Planning Inspectorate

Our ref: OR-0002198/01

Date: 04 June 2026

Application by Photovolt Development Partners (“the Applicant”) for an Order granting Development Consent for the proposed Botley West Solar Farm (“the Proposed Development”)

**Illustrative Masterplan
Figure 5.5E: Cable Corridor Option E**

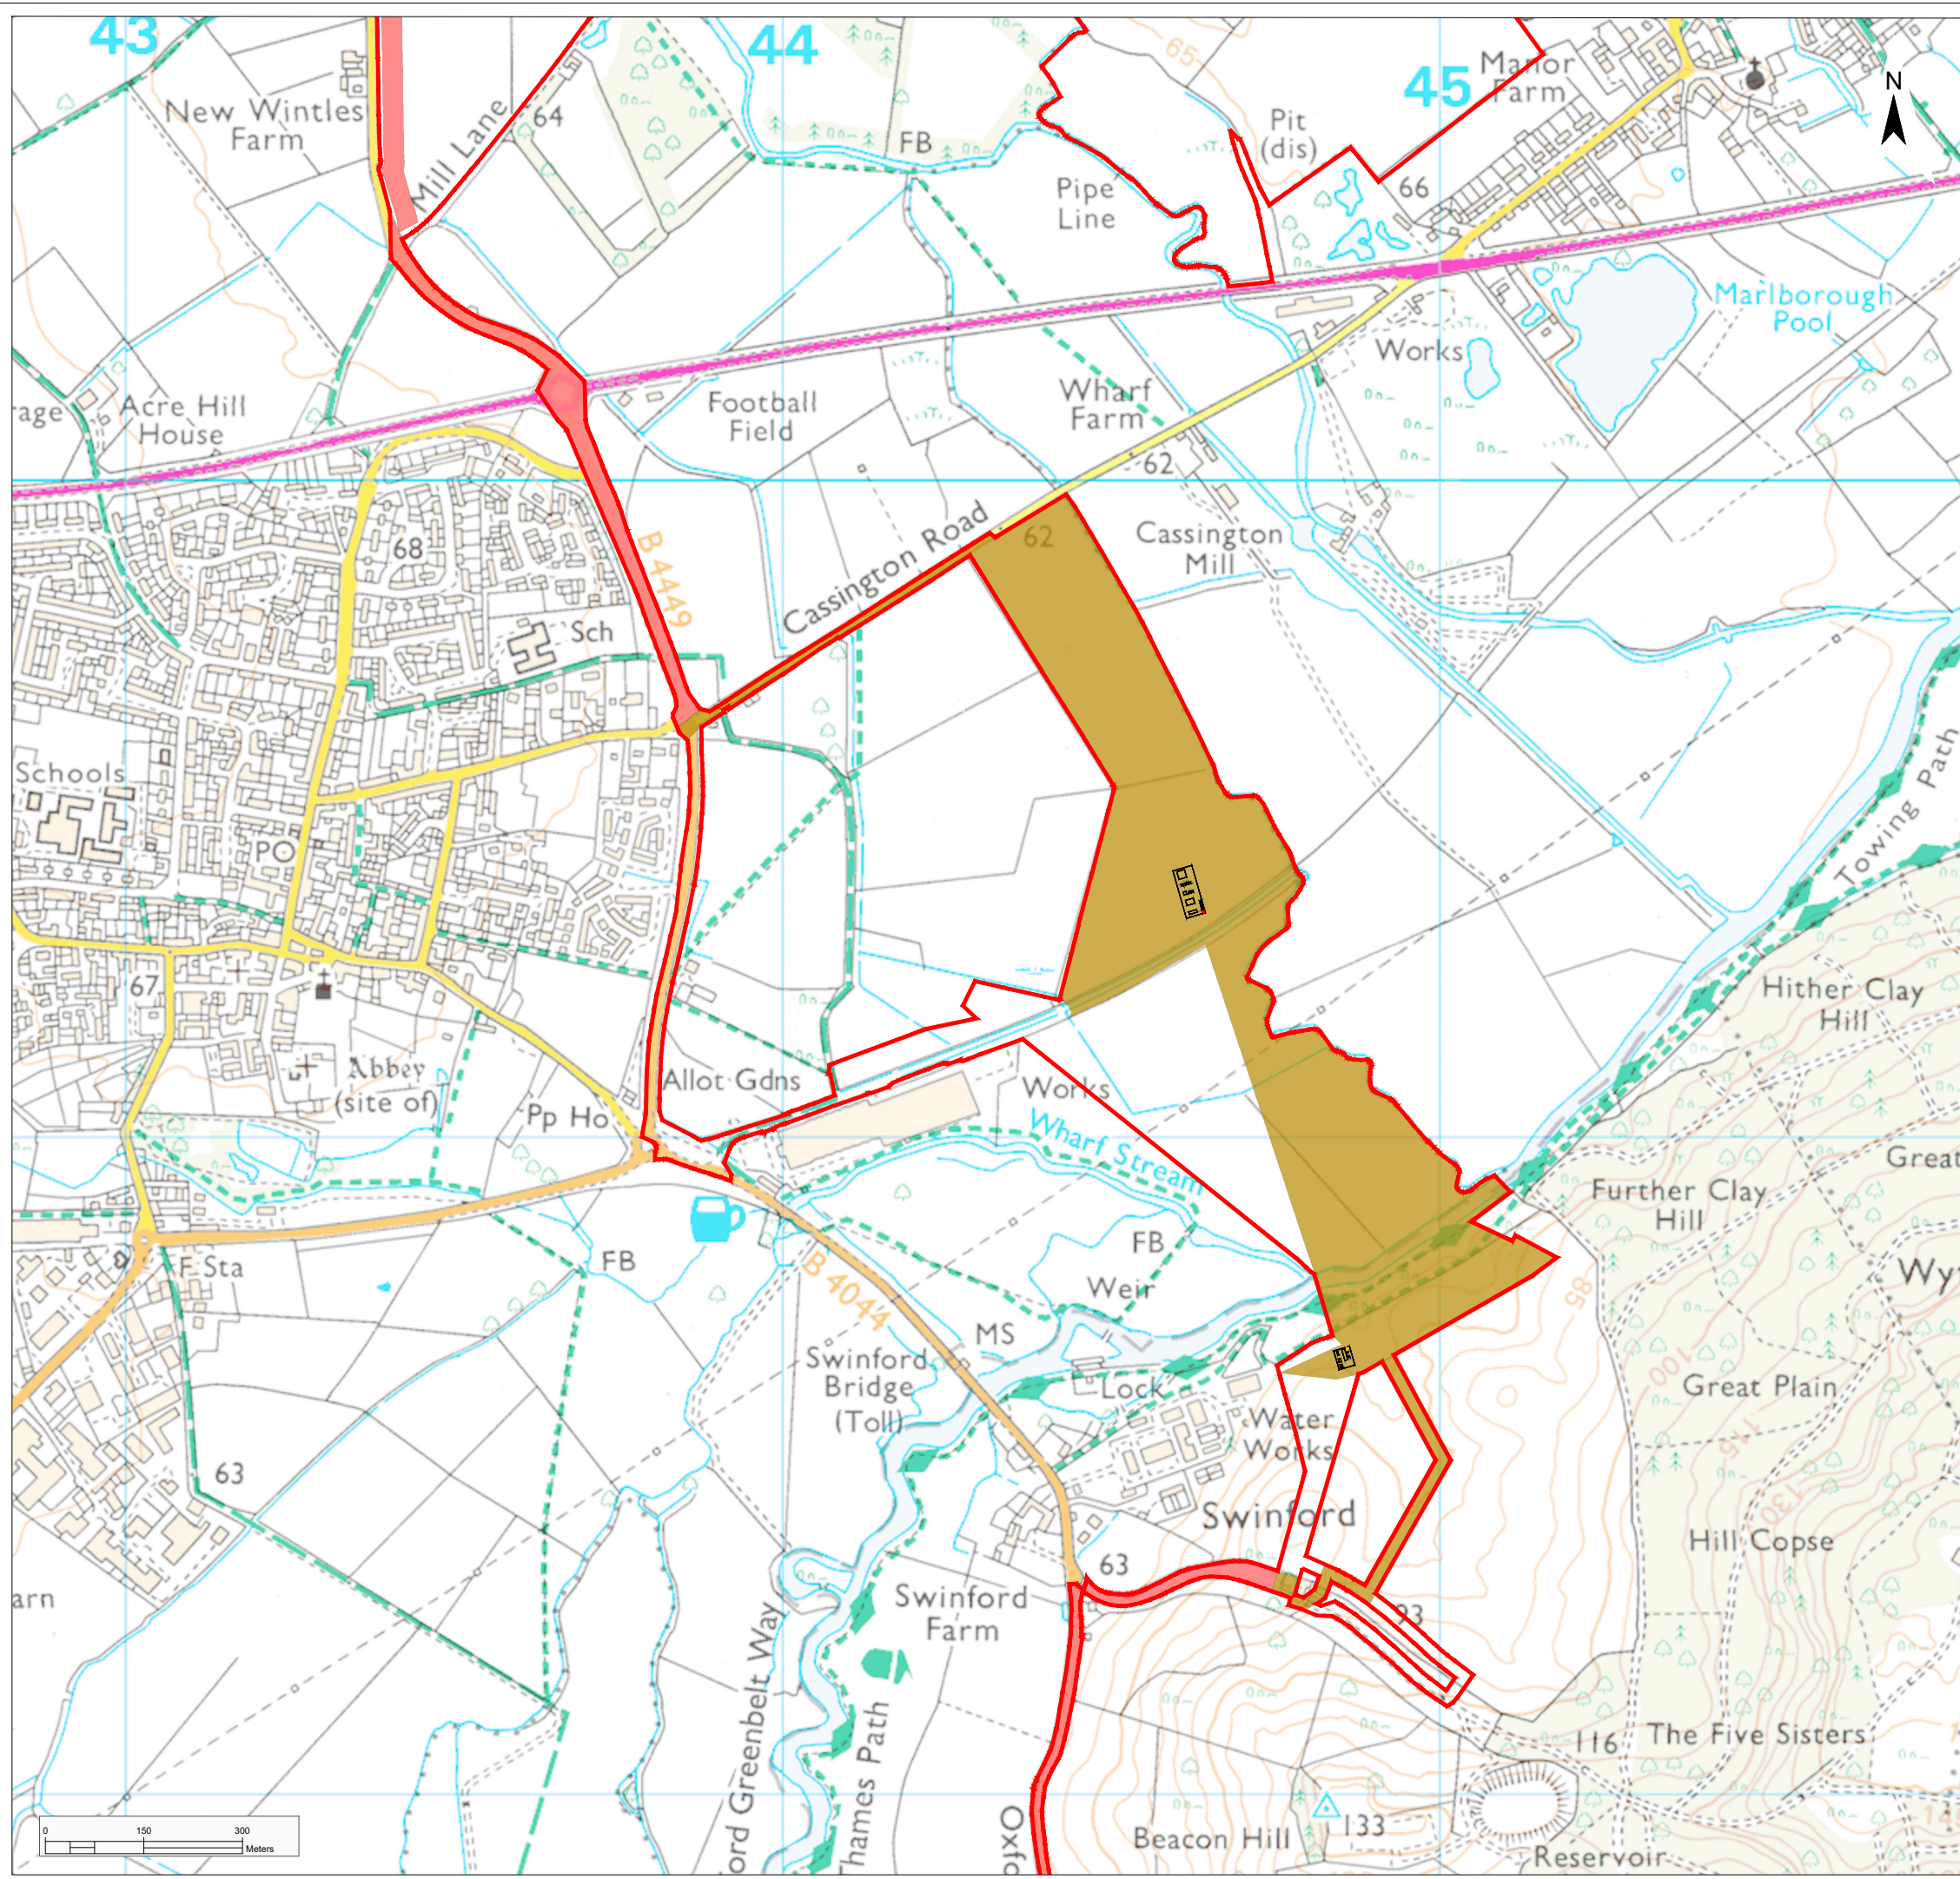
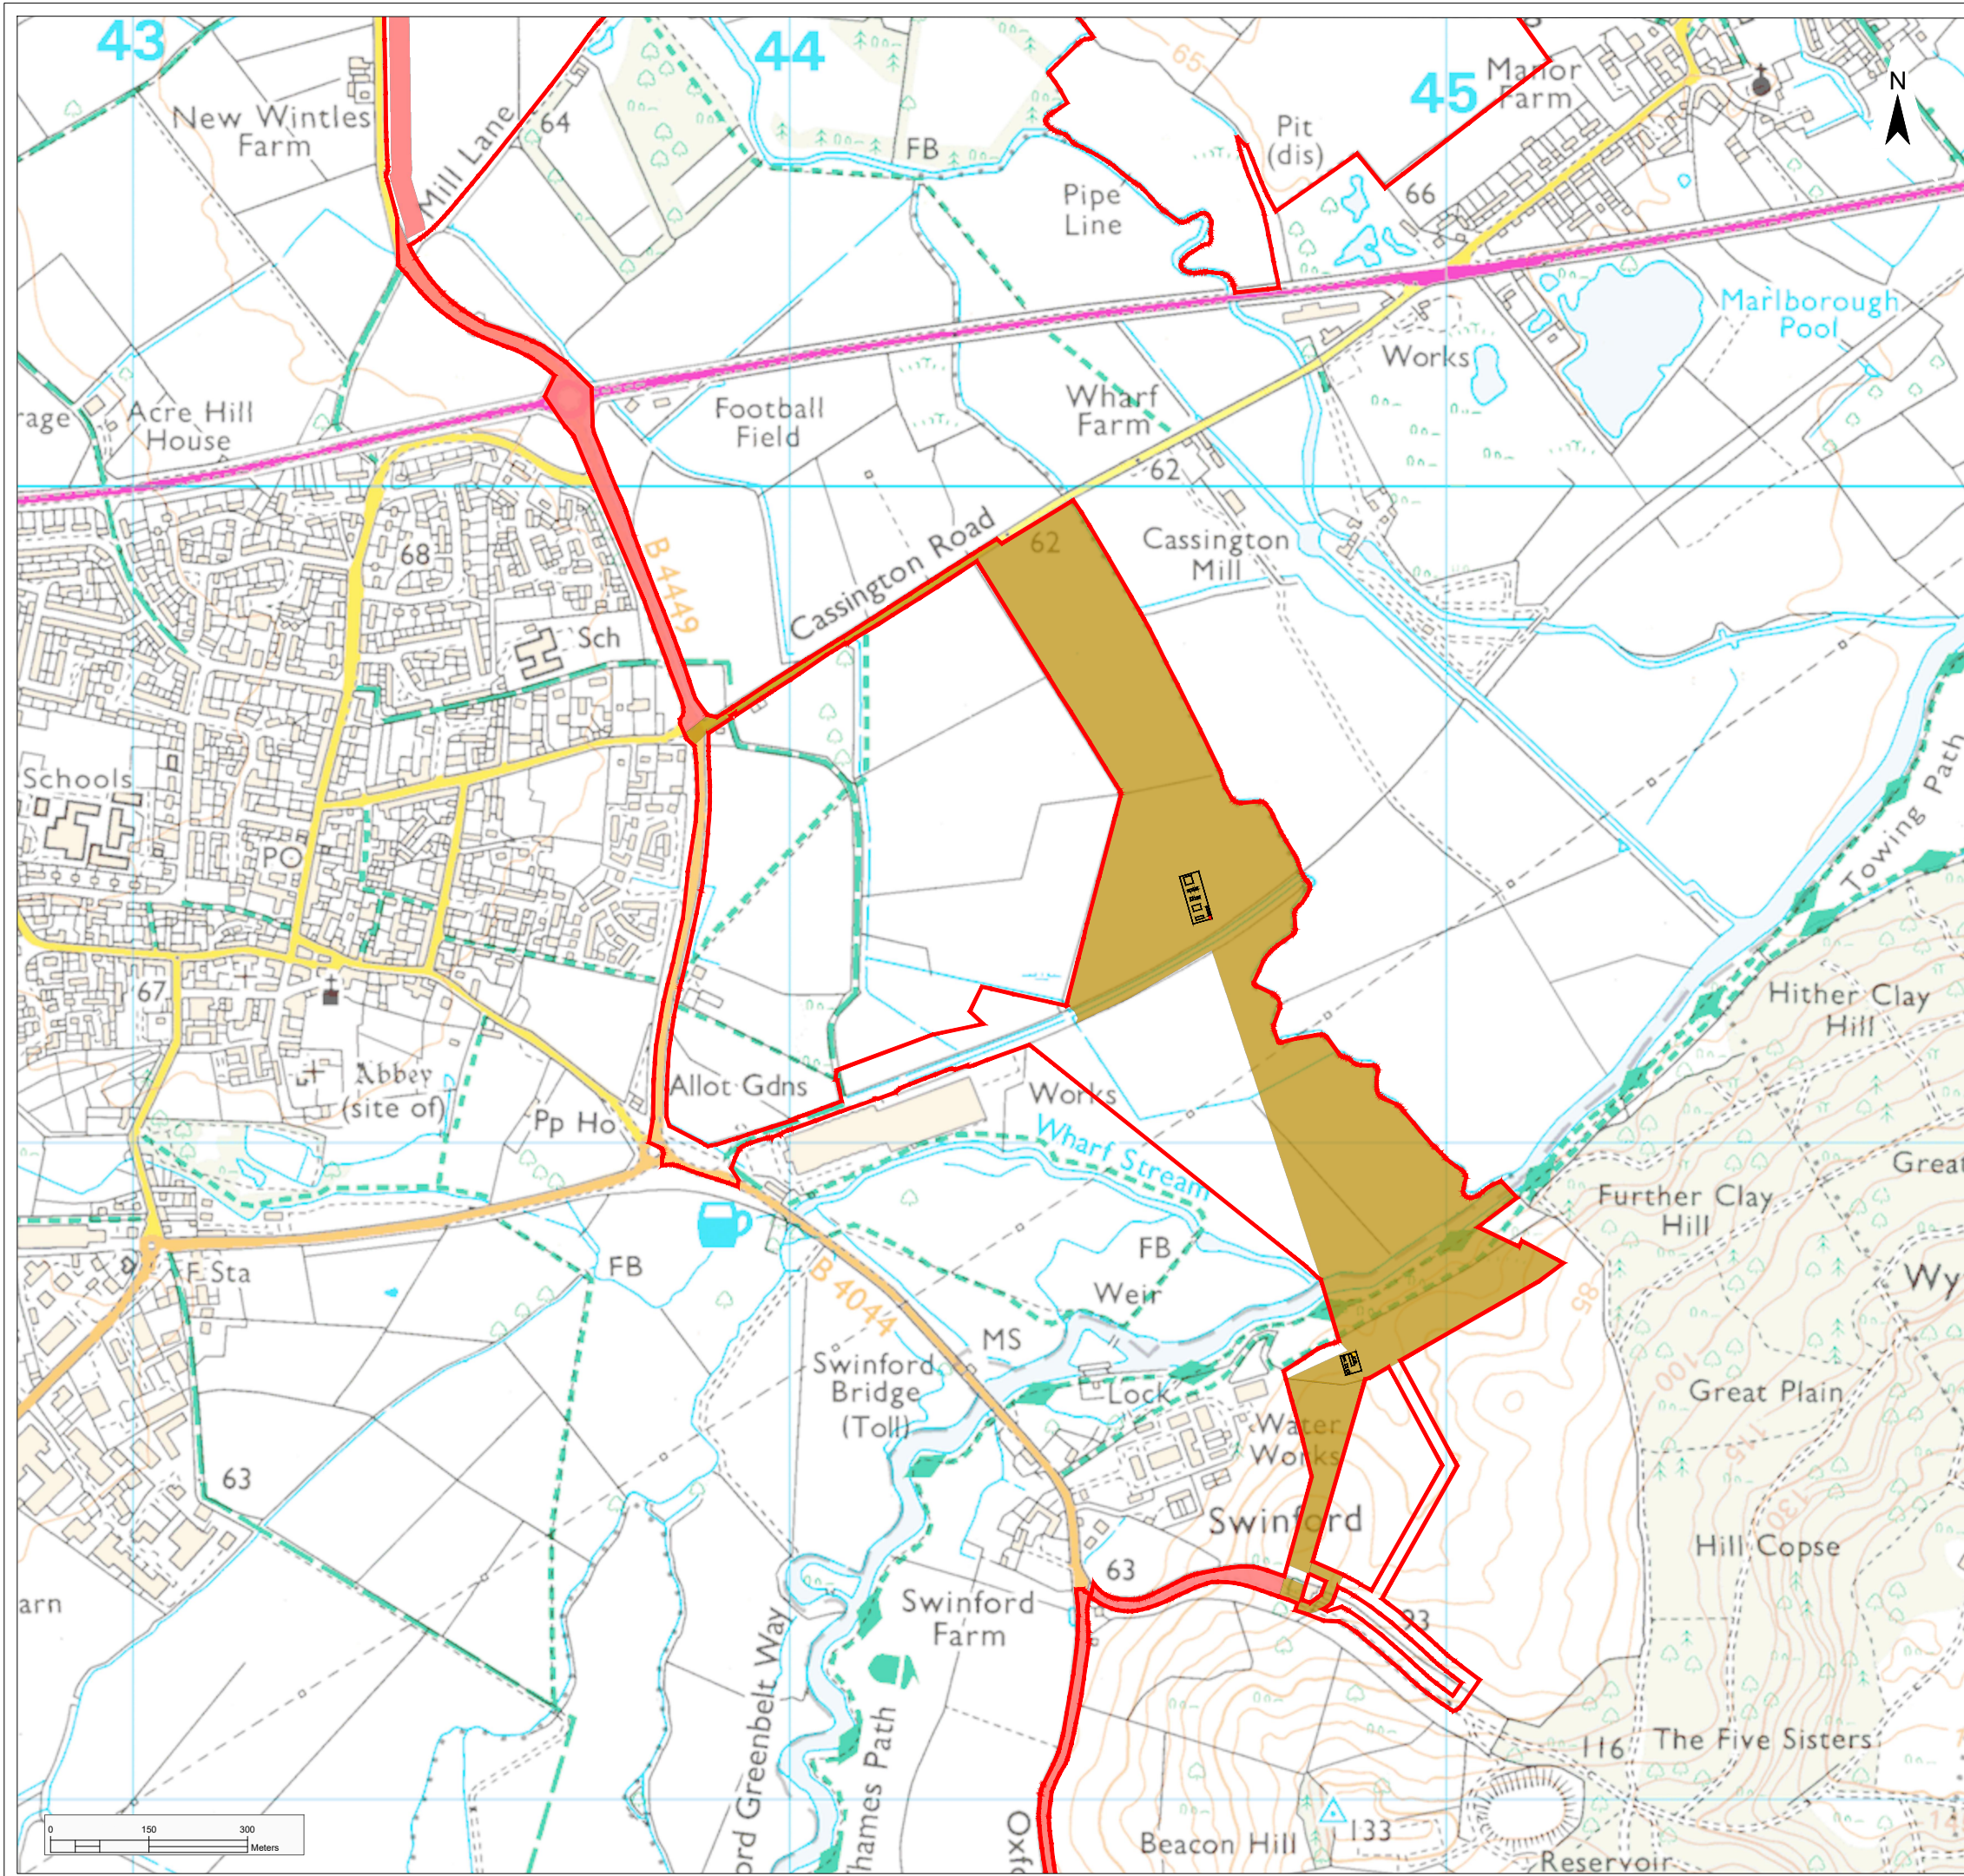
We have reviewed the Hydrology and Flood Risk Technical Note – Swinford HDD Crossings (REP6-054). The applicant has adequately justified why they are unable to move the Horizontal Directional Drilling (HDD) entrance pit at Swinford outside of Flood Zone 3b. We consider this justification is reasonable in the context of wider site-specific constraints.

Considering the proposed mitigation measures, inclusive of the additional mitigation measures (section 1.4.4), if the applicant complies with these, we consider that the approach is reasonable.
